Planning Application Number 2022/62/91044/W

I write with regard to the above planning application and my concerns arising from being the next-door neighbour.

part ground floor plan

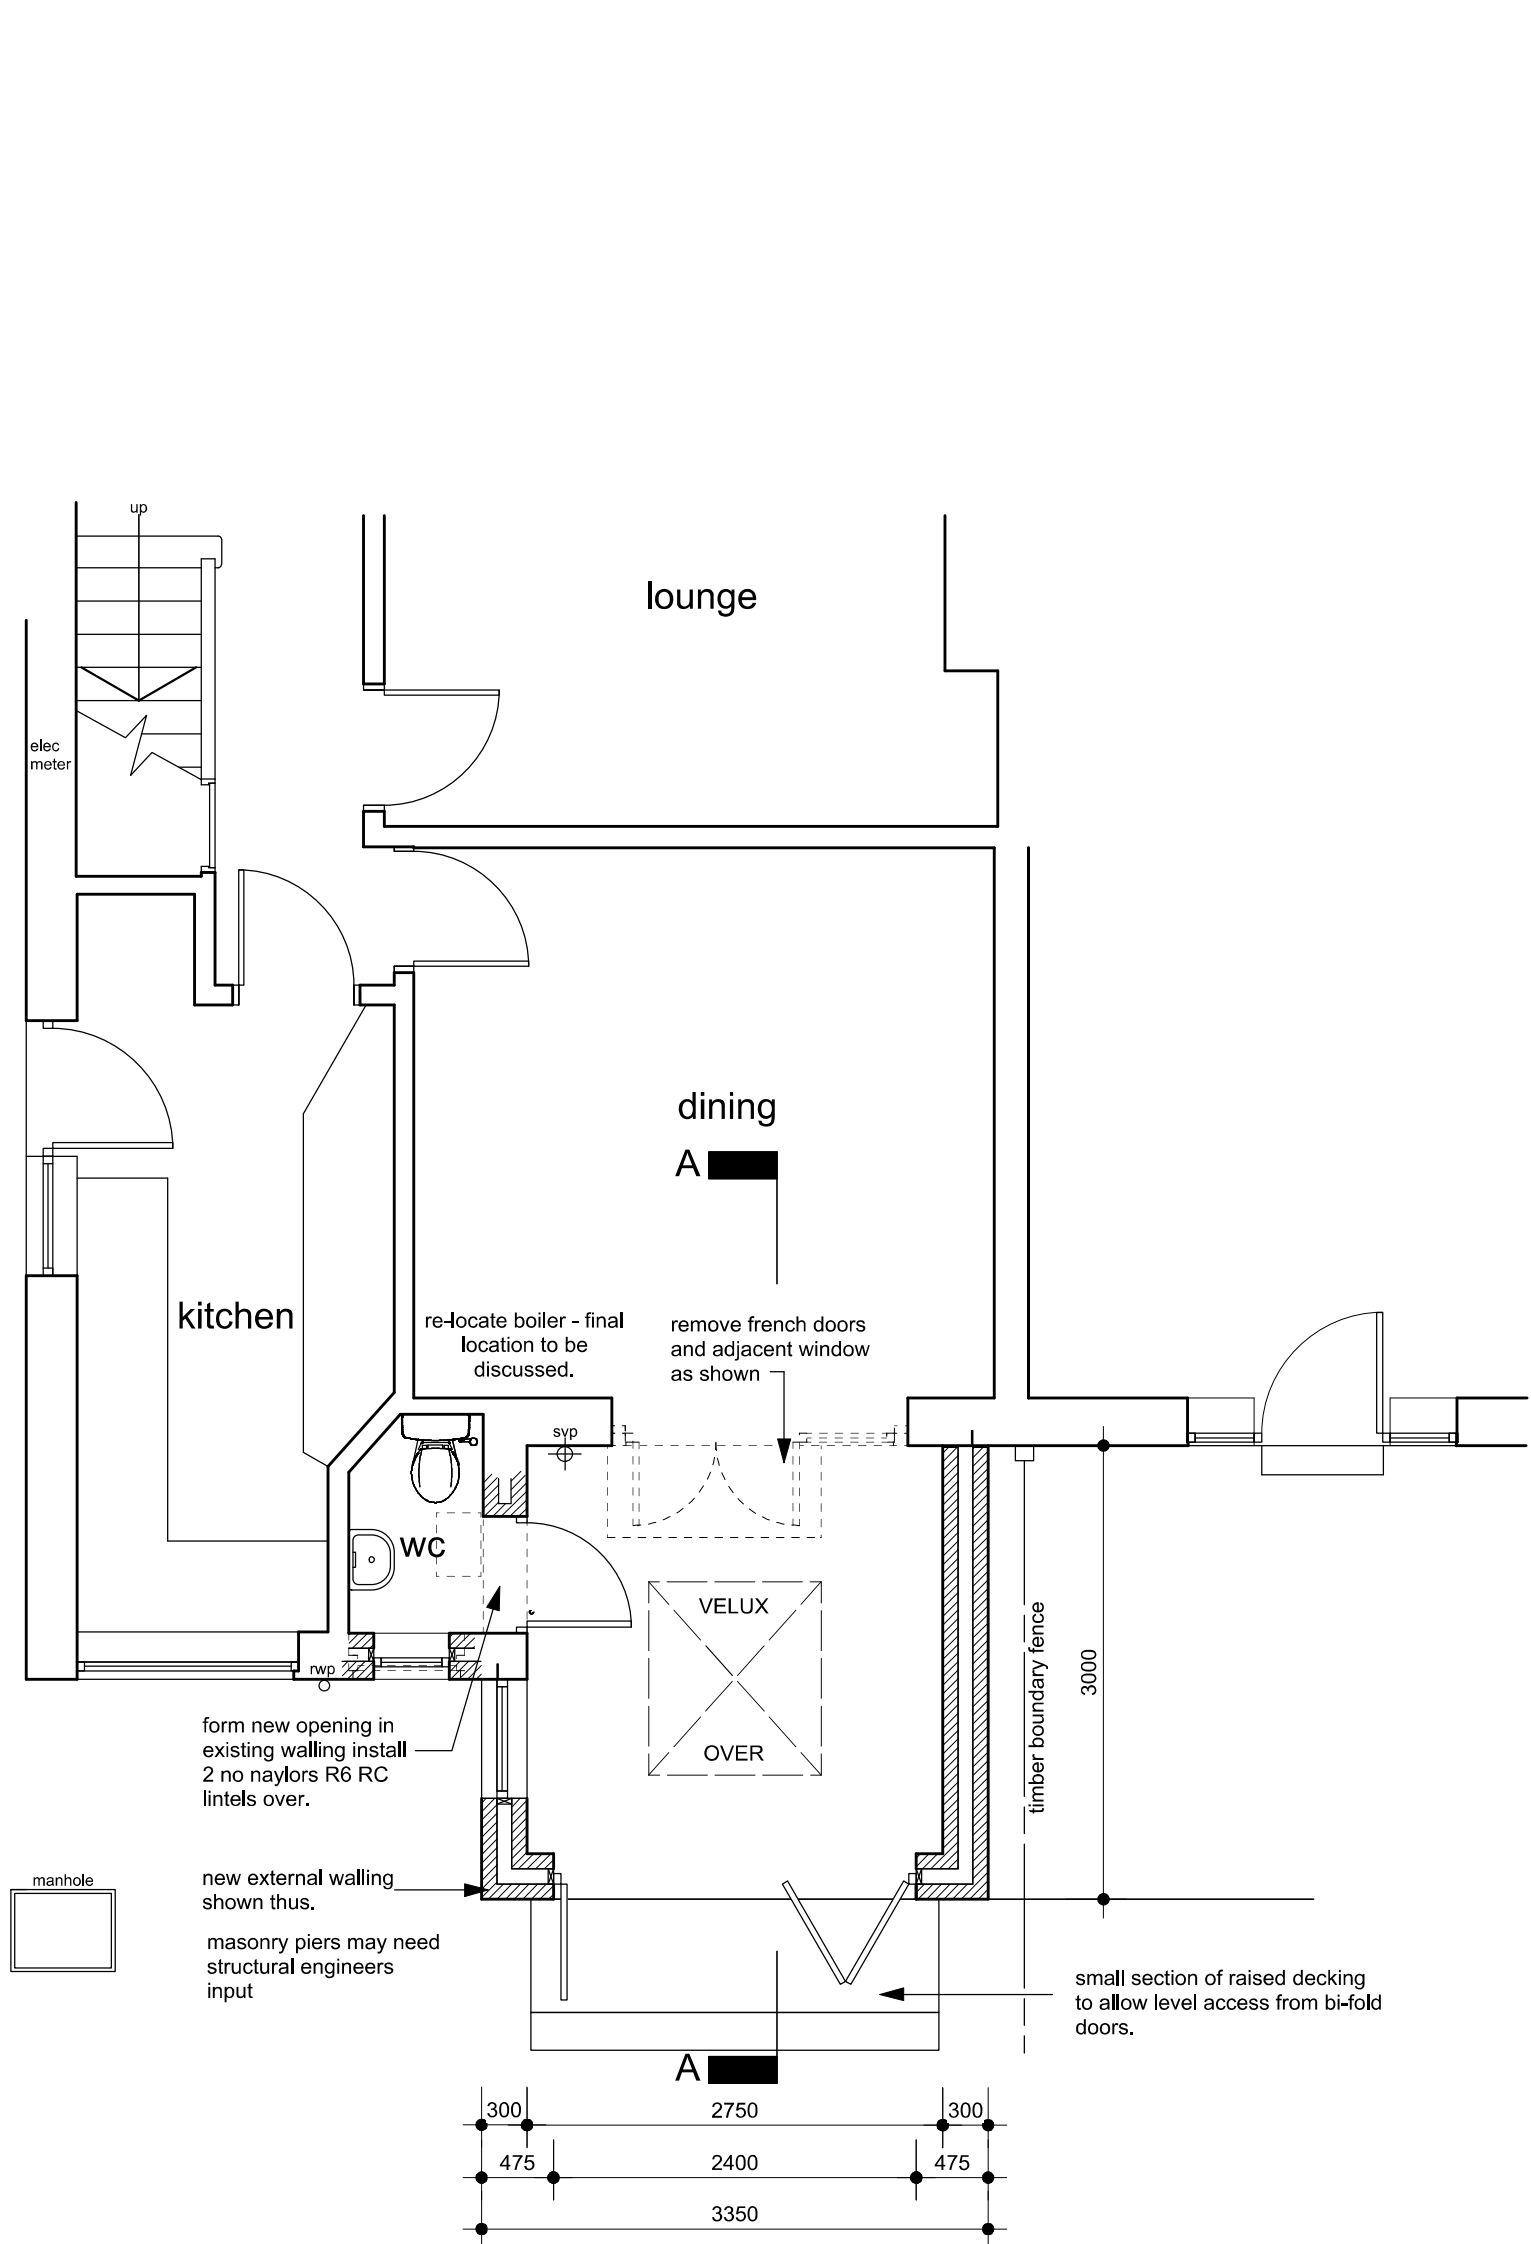
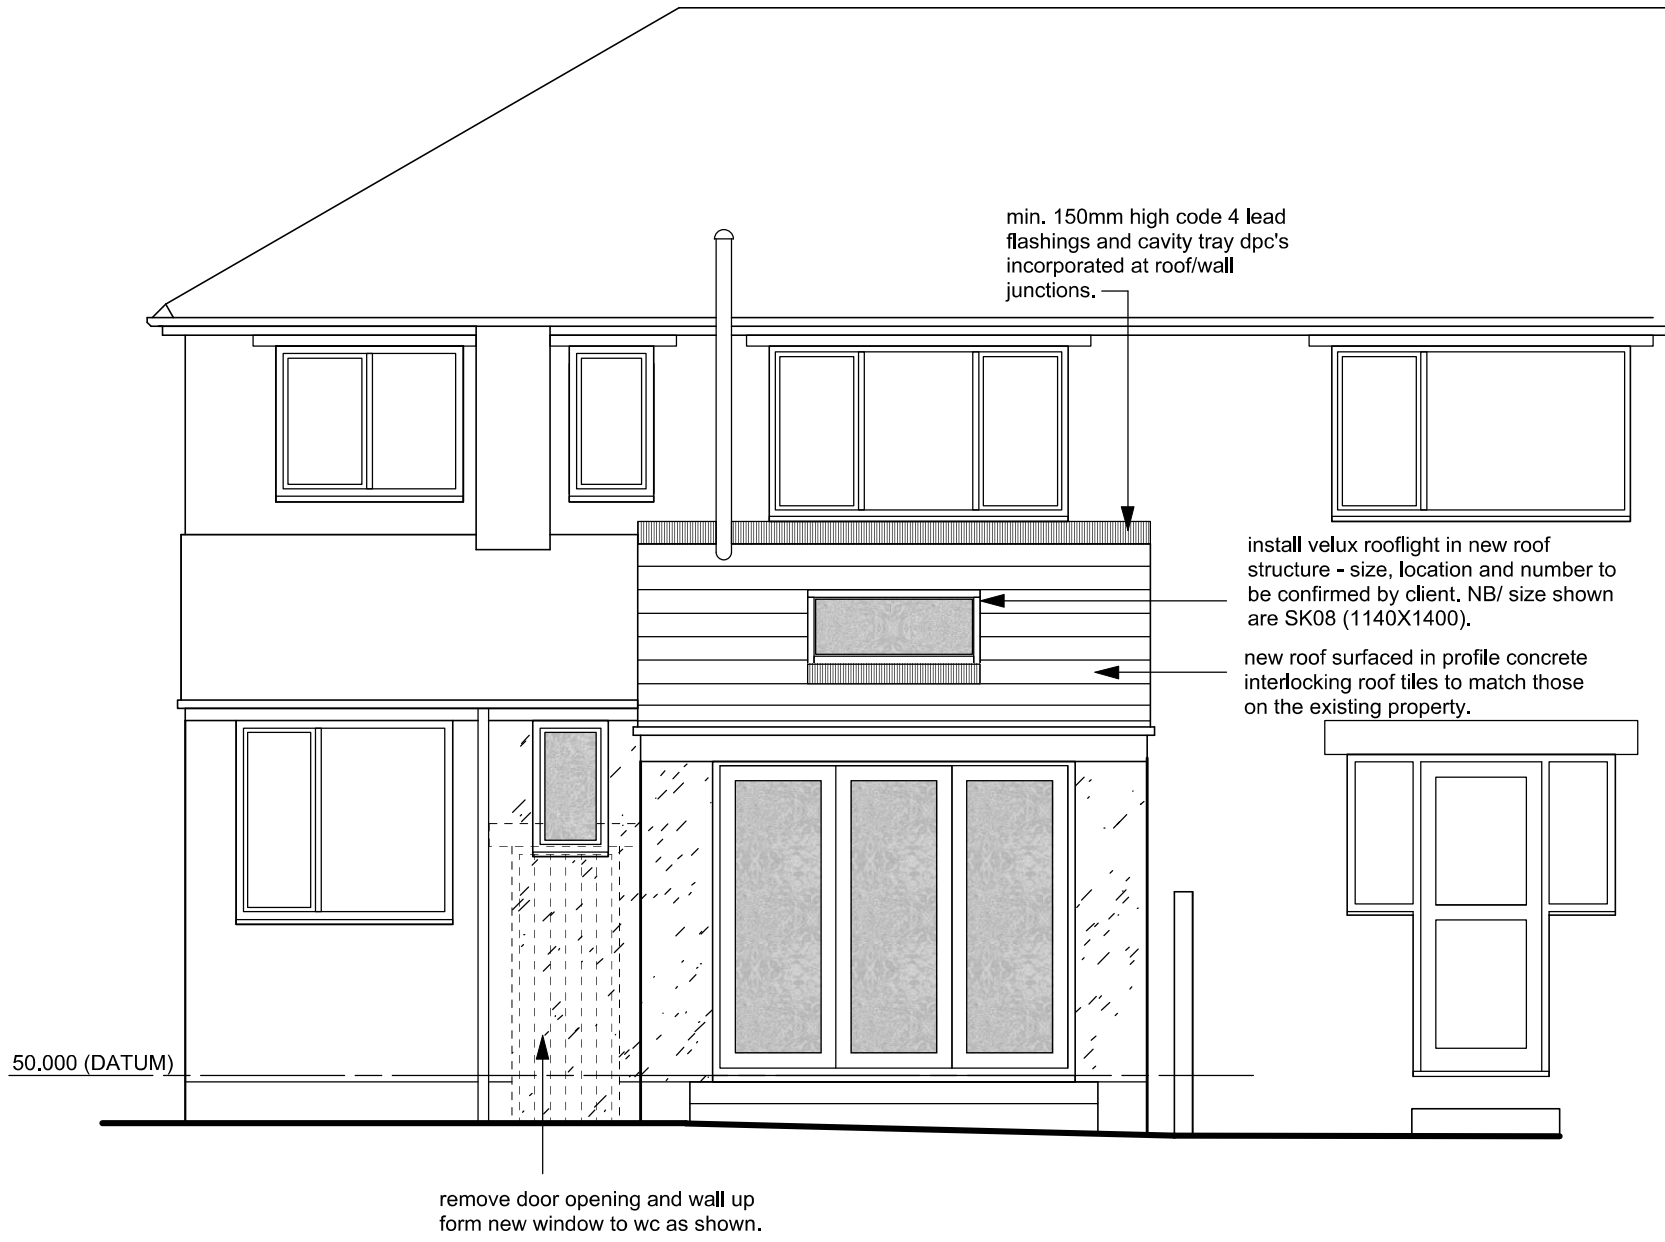
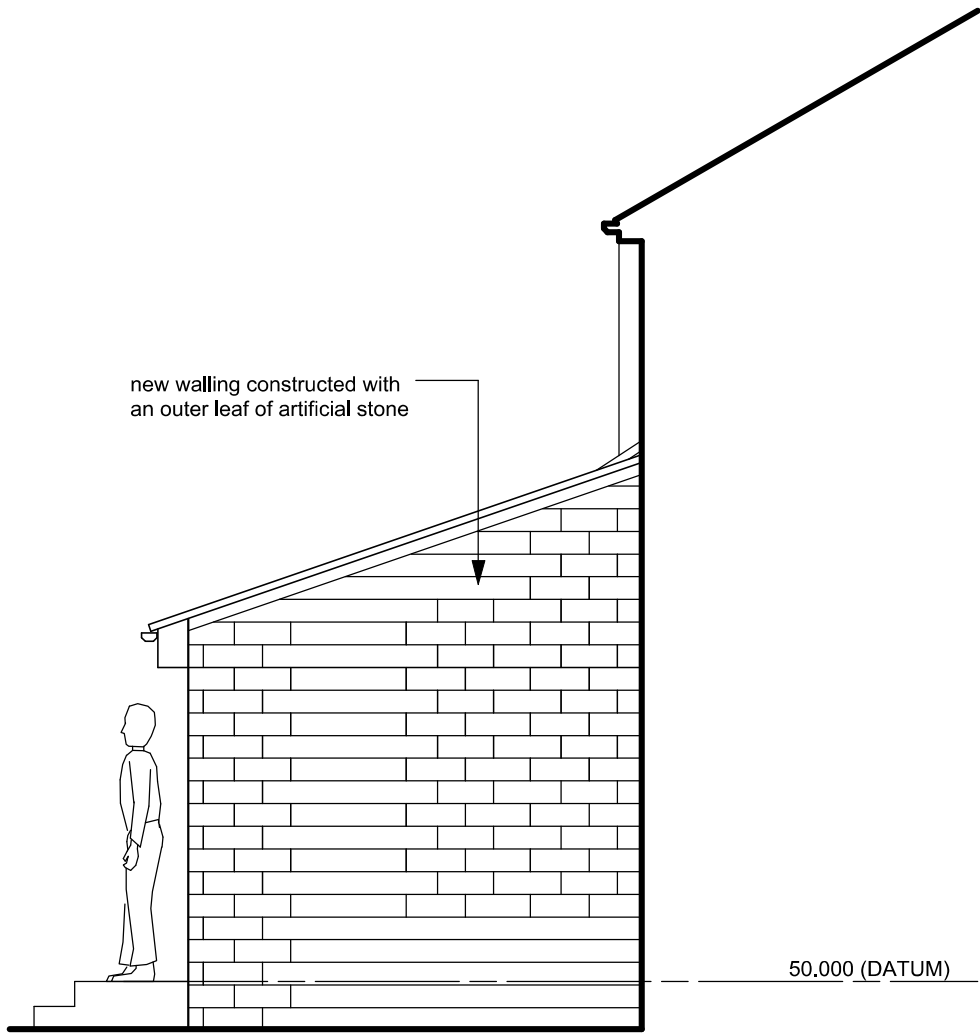
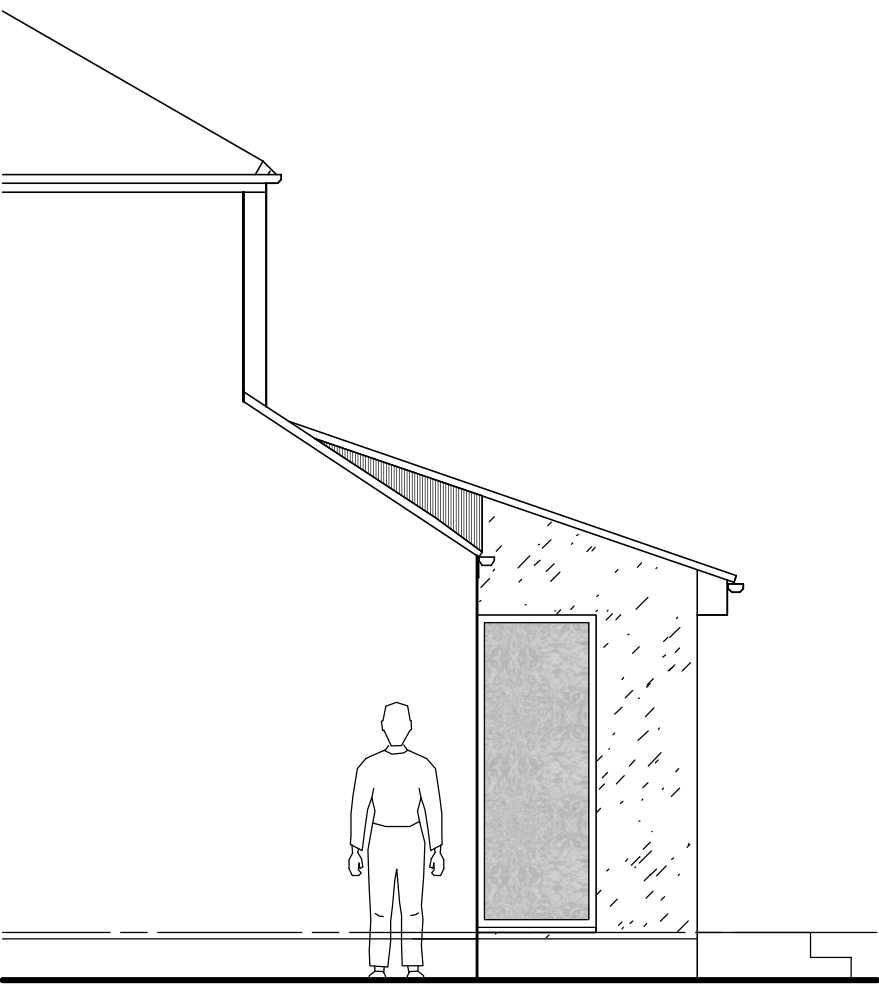
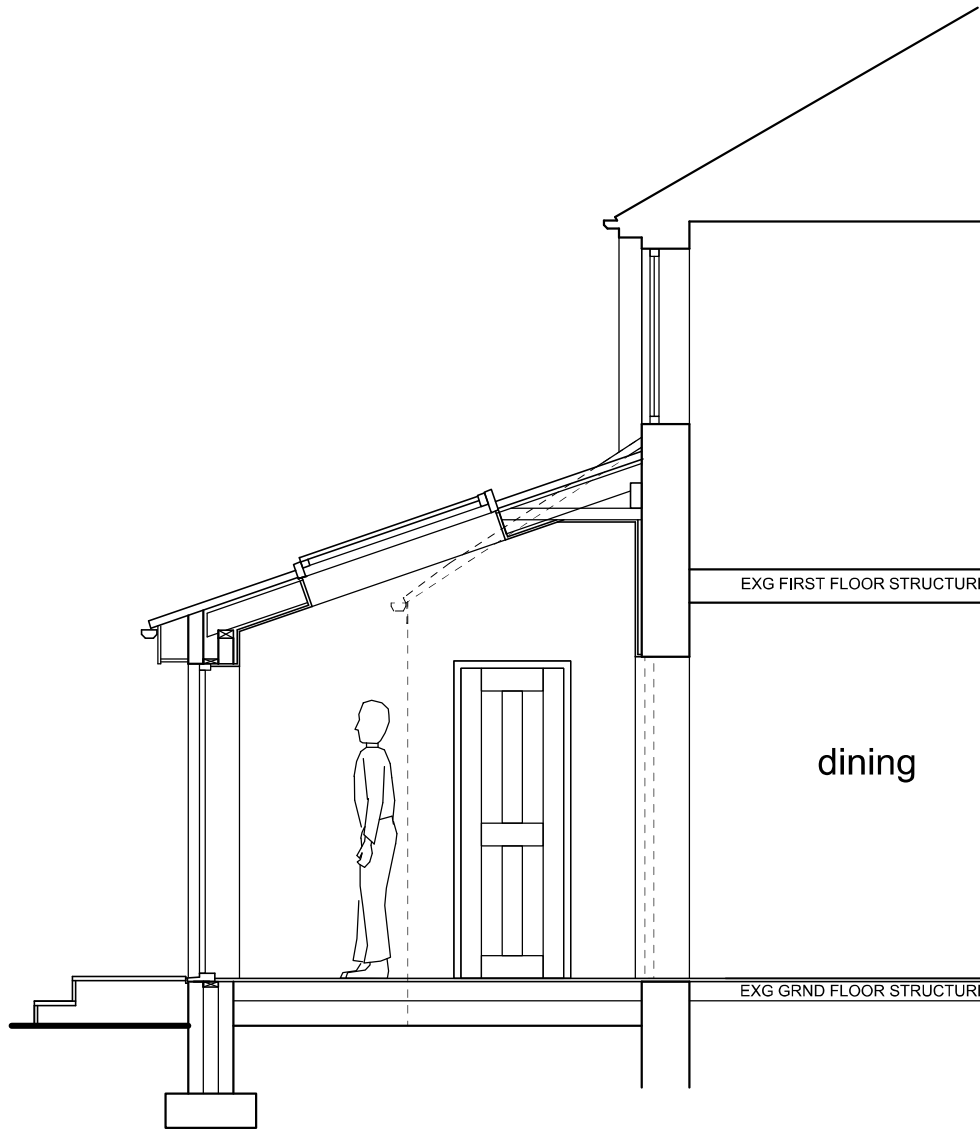
The single storey extension is extremely close to the boundary of my property and I am concerned about the effect on my property's loss of light.

As you are able to see from the drawings within the application, my main window for light in my downstairs is adjacent to the proposed structure.

It may also be that the proposed structure may also have an impact on the ability for light to reach my patio.

I am unable to see from the above, how the proposed structure would not have a detrimental effect on the rear of my property in terms of blockage of light and I would be pleased if this matter could be addressed.

No form of shading model has been included in the application.
